From: Biazar, Shahab
Sent: Wednesday, May 16, 2018 8:48 AM
To: 'Del Dixon'
Cc: Hughes, James D.; Michel, Racquel M.; Sheldon Greer; Dicome, Kym
Subject: SJRG Nazareth Center AA (1007015) Located at the NW Corner of St. Josephs St. and Atrisco Dr. N.W.

We need the following prior to approval of the AA for SJRG Nazareth Center (1007015):

**SITE PLAN**

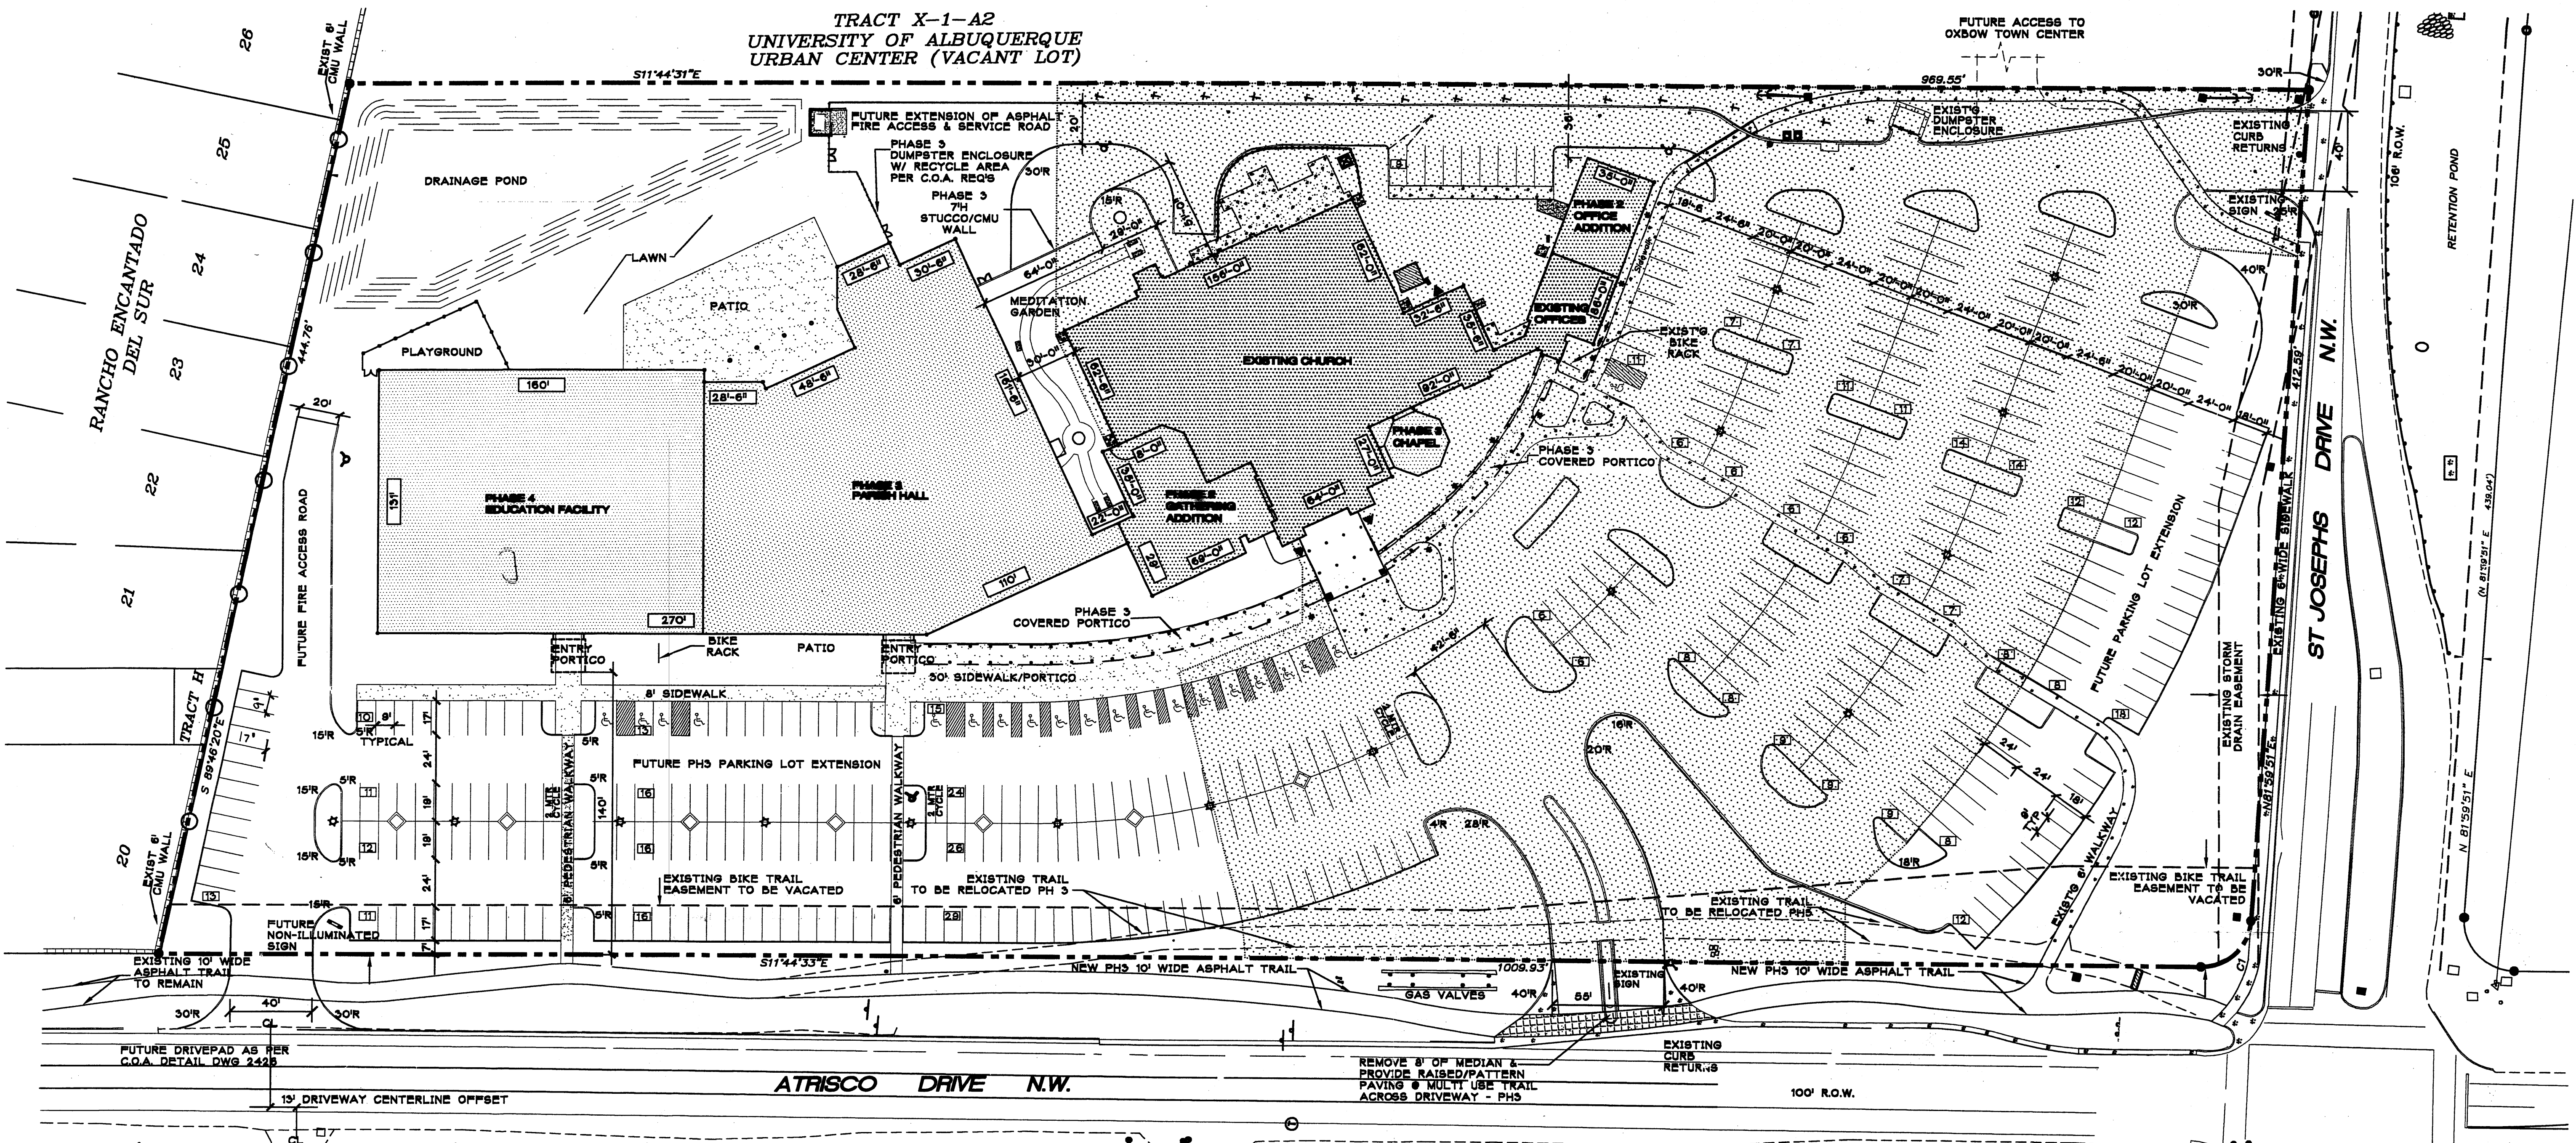
- a) Label the easement(s) on the site plan.
- b) Grading and Drainage Approval.
- c) TCL approval.
